**The Local Press**

**casey sheehan** <caseysheehan\_caseys@yahoo.com>  
To: Jeanie Bourke <jmb@portlandmaine.gov>

Wed, Jul 26, 2017 at 1:59 PM

DOORS + WIDTHS

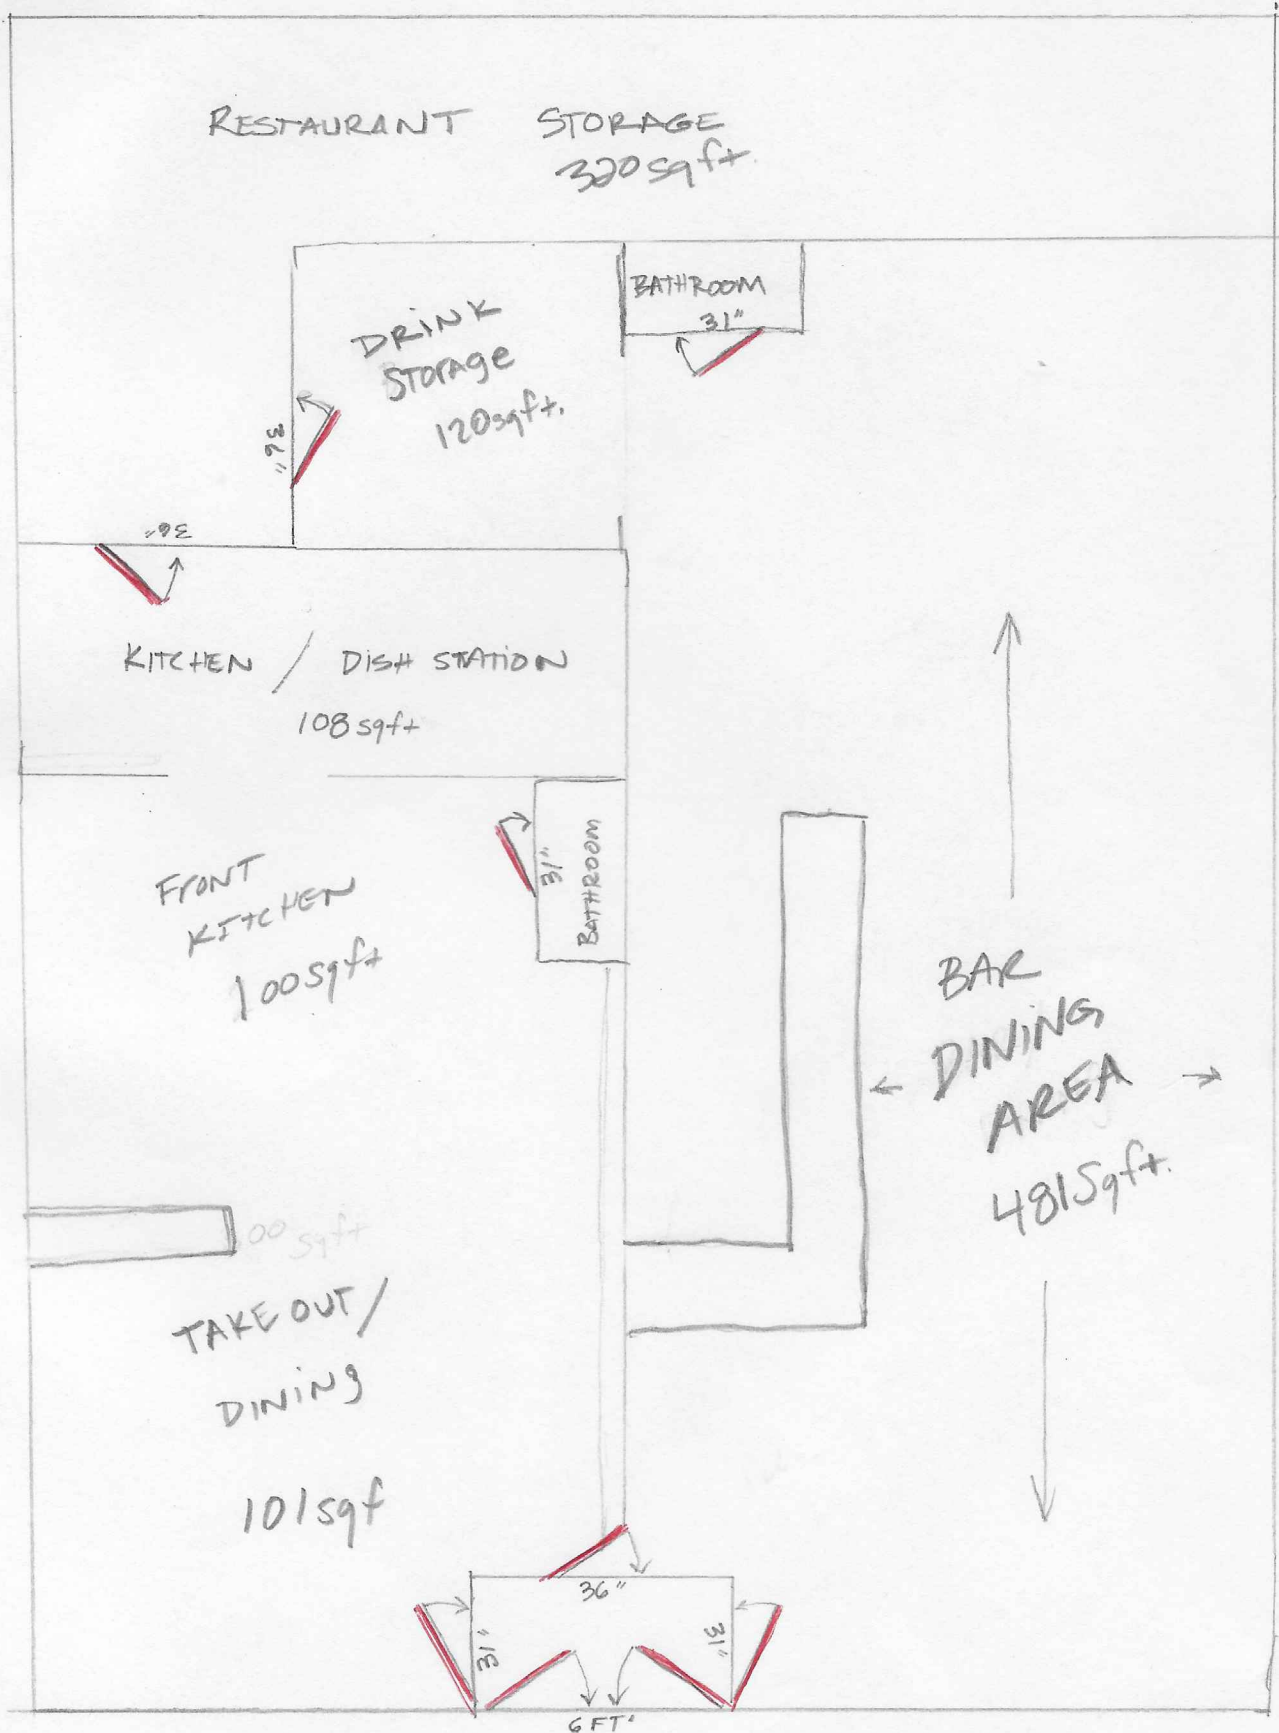
I've marked (red circles) the plan to show that there are two doors that enter into the storage space and connect the spaces so there will be no taking down or building of a doorway. As far as the tables and chairs, I won't be building a wall bench. There will be 2 chairs at each table against the wall to make as much space as possible. Each table is 23" w x 25" l and 29" tall. As far as the space that looks weirdly open in the front it's actually the front entryway. I was trying to use an app but I couldn't get it right and I'm in no way an architect or pro blueprint drawer. Each room has a public bathroom, in the proposed space it is located at the back of the room. I will mark this area as well. If you've got any other questions or concerns please feel free to contact me
